Rezoning Transportation Analysis

Petition Number: 2023-088

General Location Identifier: 12105301

Date	Description
07-26-23	First Review (PM)
08-24-23	Second Review (NK)
9-27-23	Third Review (NK)

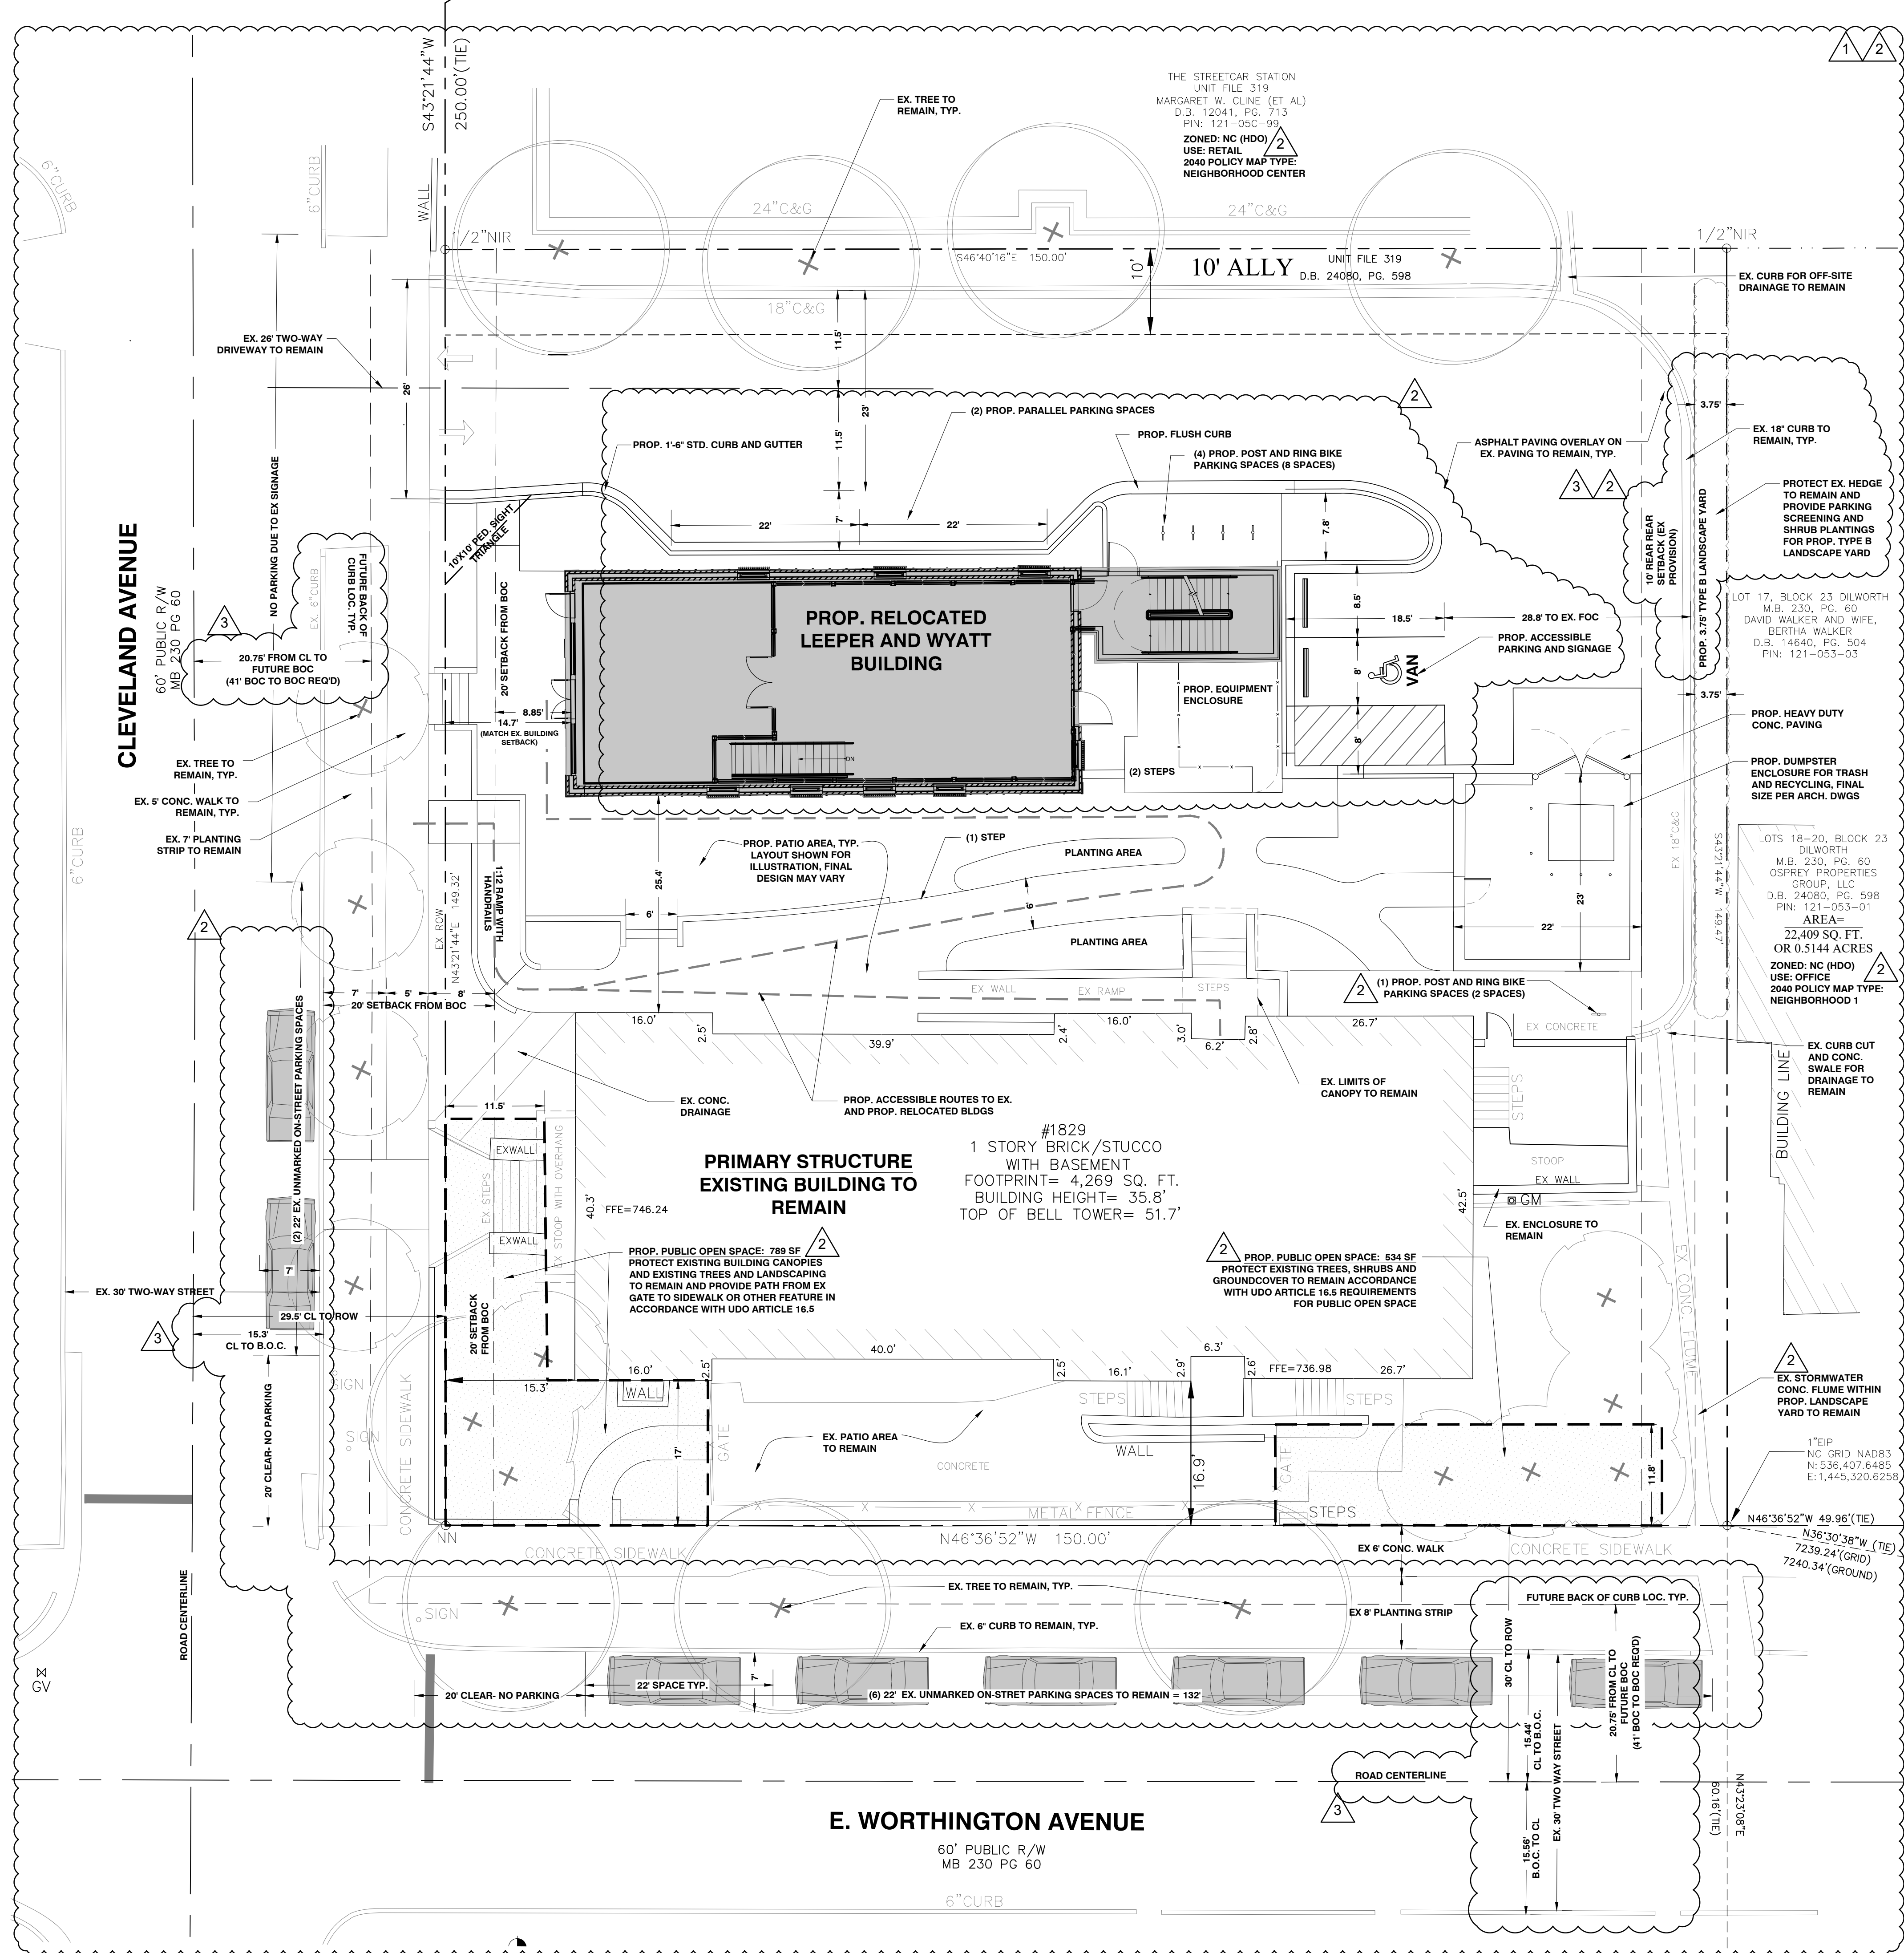
1. ~~Outstanding Issue 7/26/23~~ Curblines:

- a. ~~Cleveland Avenue: The future location of curb and gutter is to be located at 20.5ft per CLDM U-05 series for local commercial wide street typical section.~~
- b. ~~Worthington Avenue: The future location of curb and gutter is to be located at 20.5ft per CLDM U-05 series for local commercial wide street typical section.~~

Label and dimension the future back of curb location from the centerline for each road on the site plan.

~~Clarifying Comment 8/24/23: Cleveland and Worthington Avenues are both shown as 30' wide streets on current site plans. These streets must be at least 41' wide from back of curb to~~

back of curb per CLDM U-05. Additionally, each road must label and dimension future back of curb location to the centerline.

4. ~~**Outstanding Issue 7/26/23:** Revise site plan to show the centerline on each public street. Dimension the right-of-way and the back of curb from the centerline.~~

5. ~~Revise site plan to clarify if the wall is proposed or existing. If the existing wall is being replaced, CDOT would prefer that it be placed outside of the right-of-way, otherwise will need an encroachment agreement.~~
